The Member Secretary,
Chennai Metropolitan
Development Authority,
No.1, Gandhi Irwin Road,
CHENNAI - 600 009

Letter No. 3/40764/2002

Area Plans Unit - Planning permission -
Proposed construction of Ground Floor + 3 floors
residential building with 8 dwelling units at Plot
No. 68, Old No. 4, New Door No. 7, S.S.No. 231/8 and
231/69, Block No. 15, Ramanathan street, Egmore
Division, Kilpauk, Chennai - Resubmission of Development
Charges and other charges - Regarding

SITE CUM GROUND FLOOR PLAN

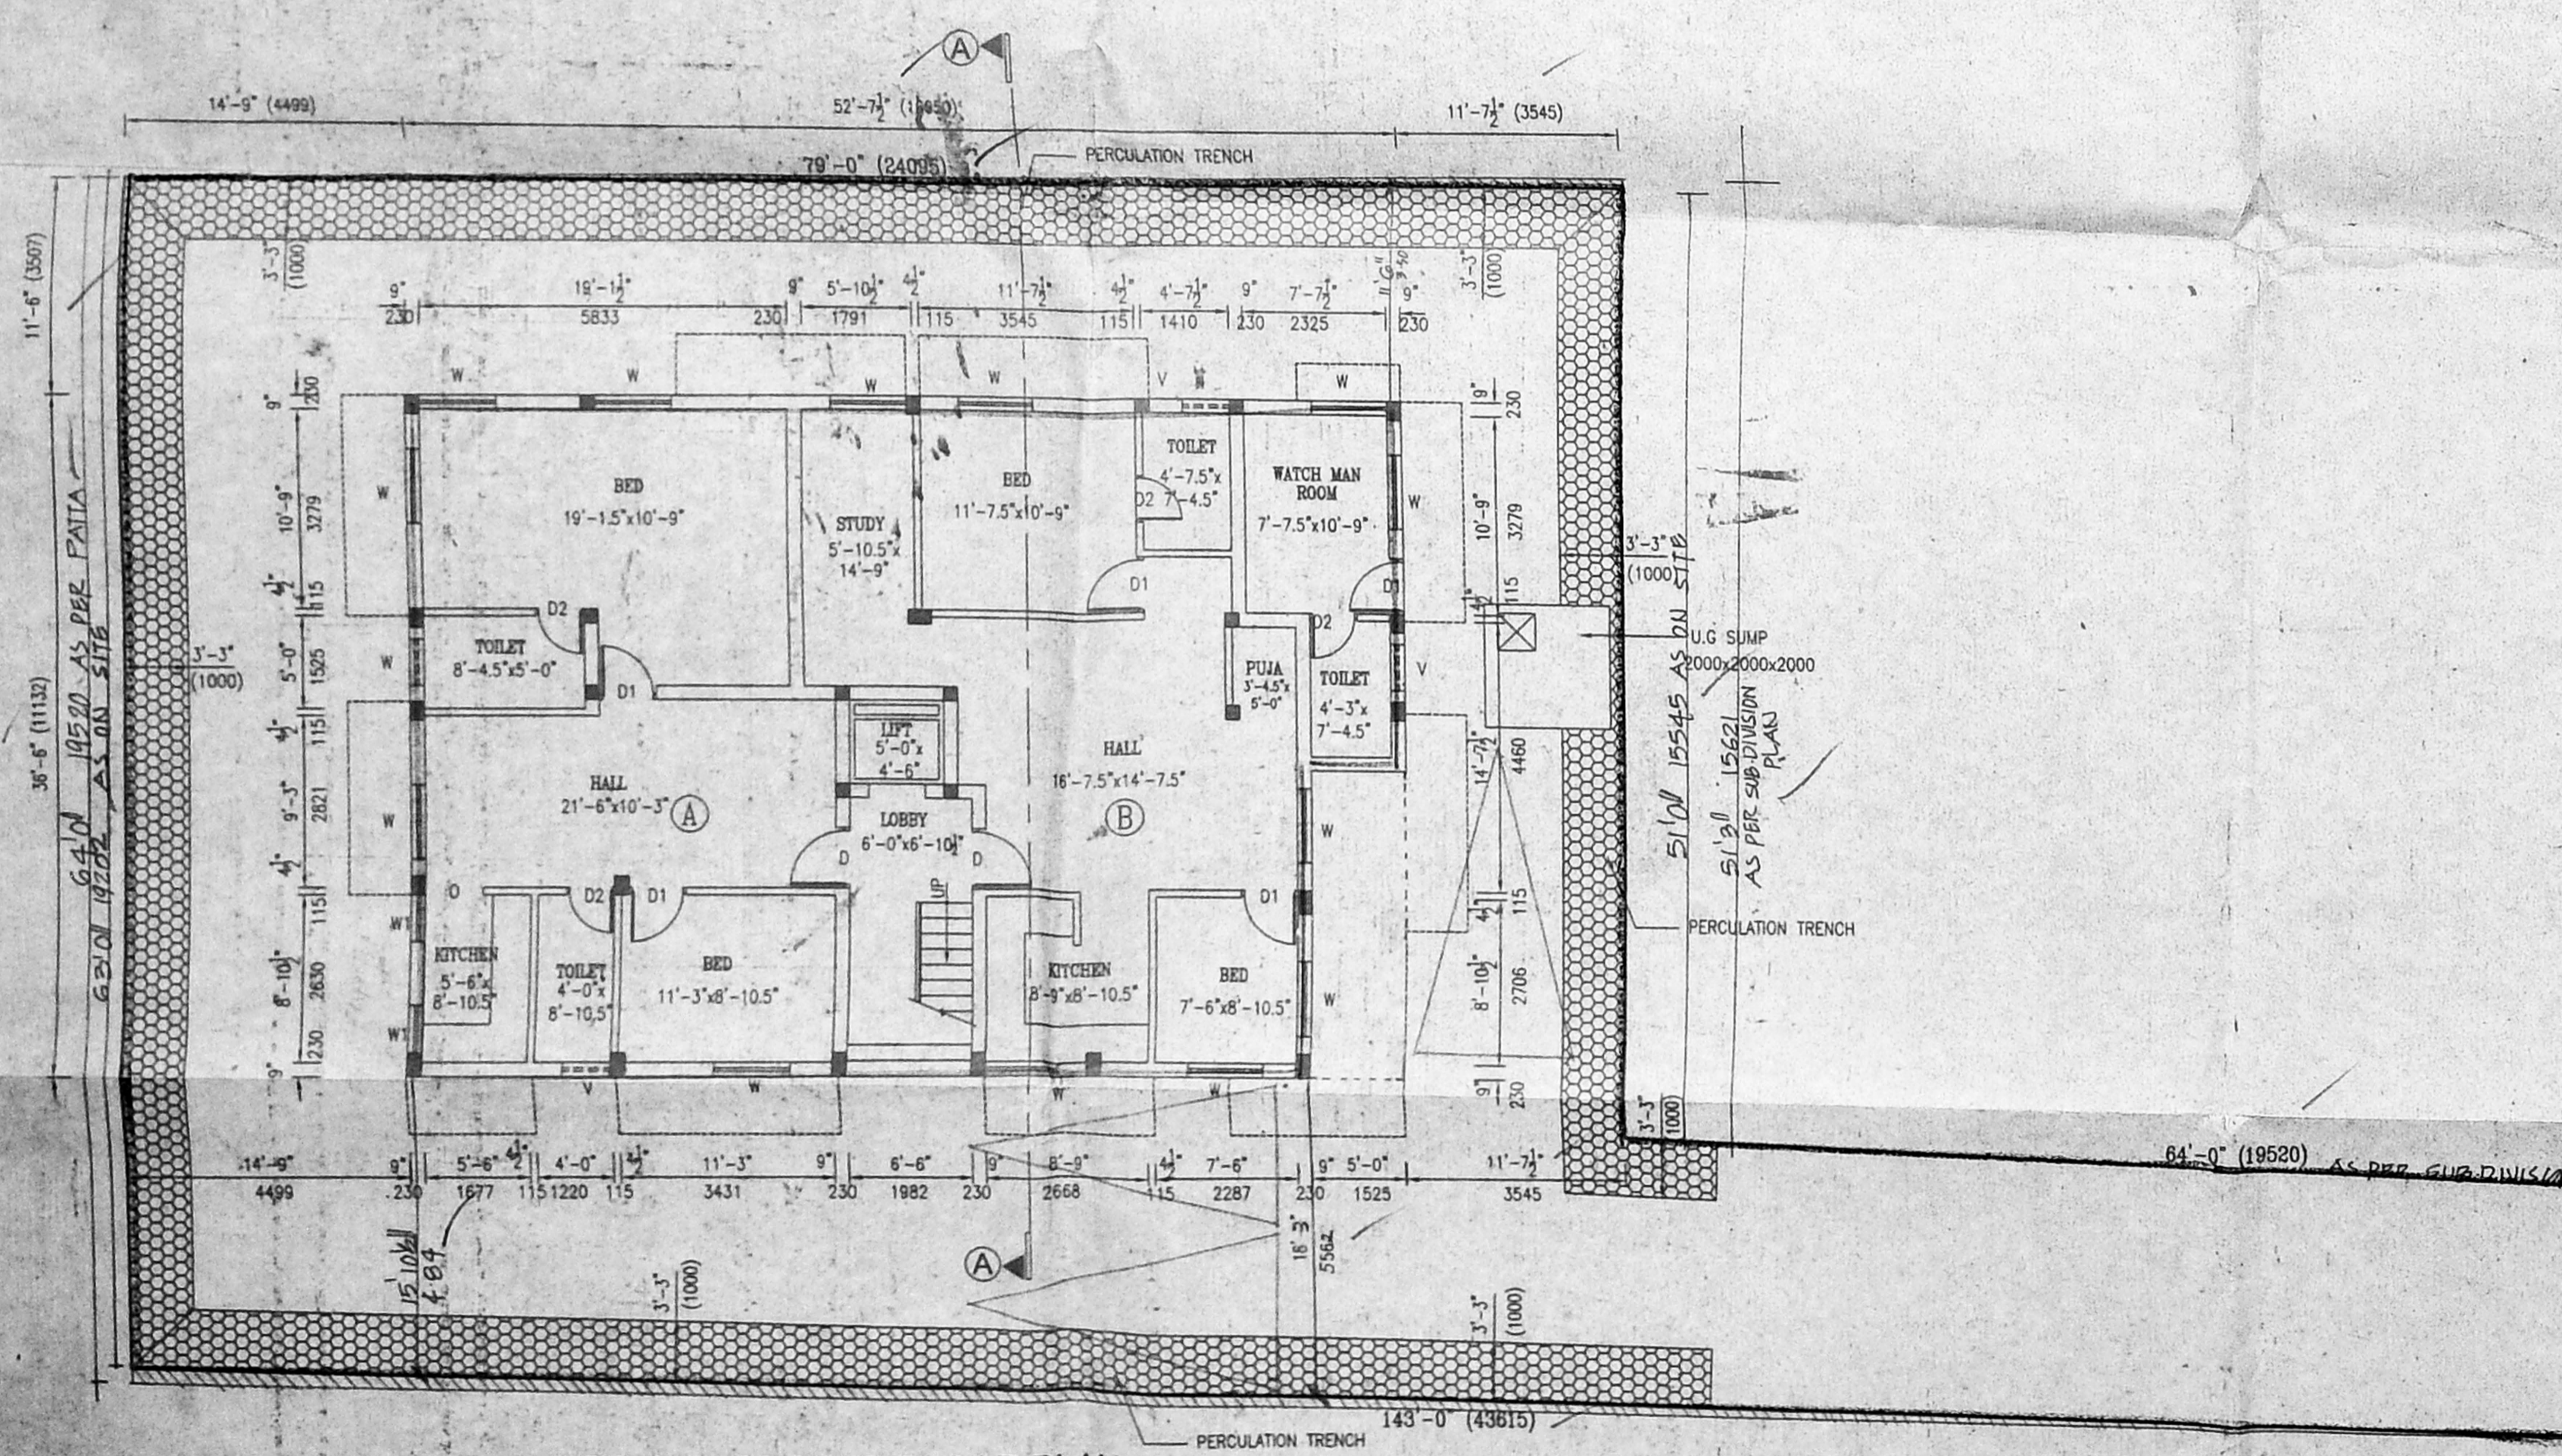
- 6) **Five** copies of revised plans, tallying the elevation with reference to detail plans and mentioning the total height.
- a) Site plans showing the site dimension as per site condition and as per FIA, distinguishing the difference by hatched indication and showing the set measurements from the least dimension line satisfying DCR to be furnished
- c) The breaking measurements including the set backs should tally with over all dimension and comply DCR.
